Planning Application Ref: BR/49/19/OUT

Location: 26 Burnham Avenue, Bognor Regis, PO21 2JU

Description of works: Outline application with all matters reserved for 22 No. new dwellings consisting of 2 No. 1 bed dwellings, 18 No. 2 bed dwellings & 2 No. 3 bed dwellings

Mark Warwick
Tree Officer / Parks and Greenspace Team

Roof / Site Plan (Proposed) 1:200

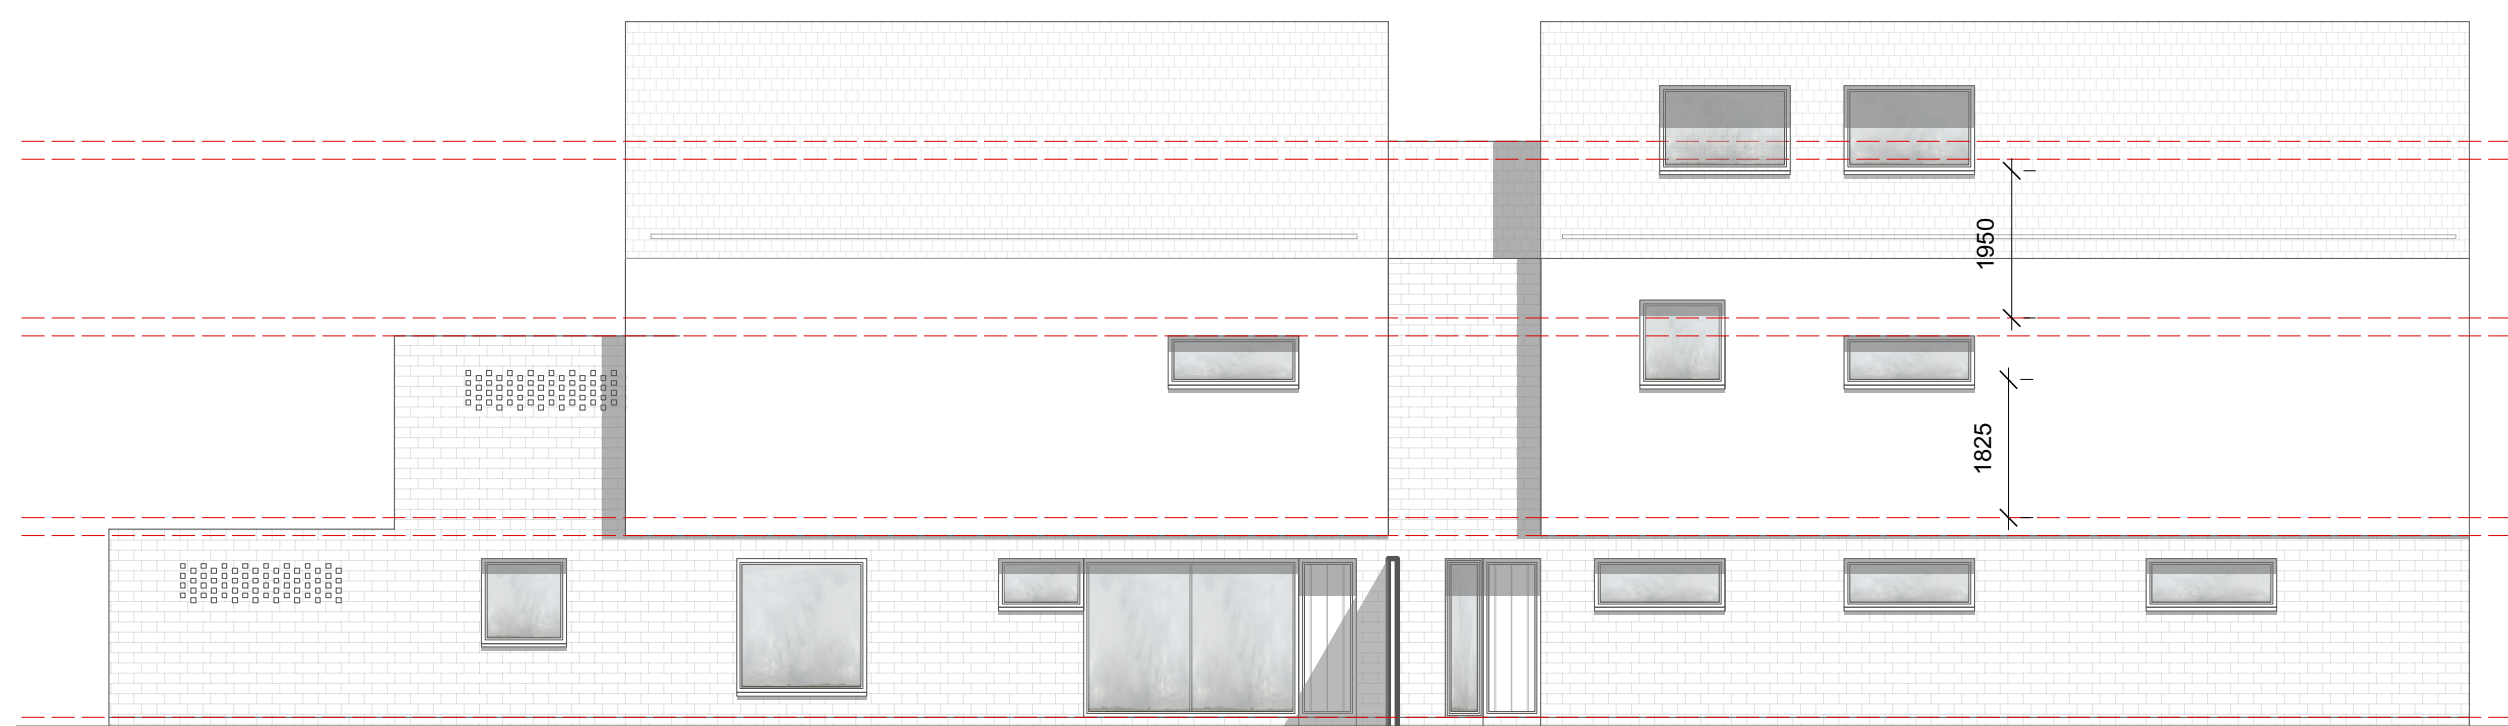
- There are significant trees at this site which will be adversely affected by the proposals. There is no supporting arboricultural information submitted with the application - a requirement of BS5837:2012. As such, were this application to now proceed, we will not have sufficient information to guarantee such trees would be adequately respected and protected.

- In the absence of any arboricultural information in support of this application, I am compelled to register an **OBJECTION** at least until such time as those reports and plans have been provided, and in accordance with the requirements of BS5837:2012 – Trees in relation to Design, Demolition and Construction (see below).

1. The applicants will need to employ the services of an Arboricultural Consultant to carry out a tree survey exercise and then prepare an Arboricultural Implications Assessment (AIA) which must be inclusive of; a 'Tree Survey Schedule', a 'Root Protection Area (RPA) Schedule' and a 'Tree Constraints Plan' – with the trees accurately plotted on same.
2. In the event that a RPA of any tree which is proposed for retention overlaps the development then BS5837:2012 requires that the Detailed Planning Application is accompanied by an Arboricultural Method Statement (AMS) and also most importantly a Tree Protection Plan – to both describe and illustrate the mitigation measures which are to be employed to ensure that the trees survive without detriment to their vigour and vitality and are given adequate protection both above and below ground.
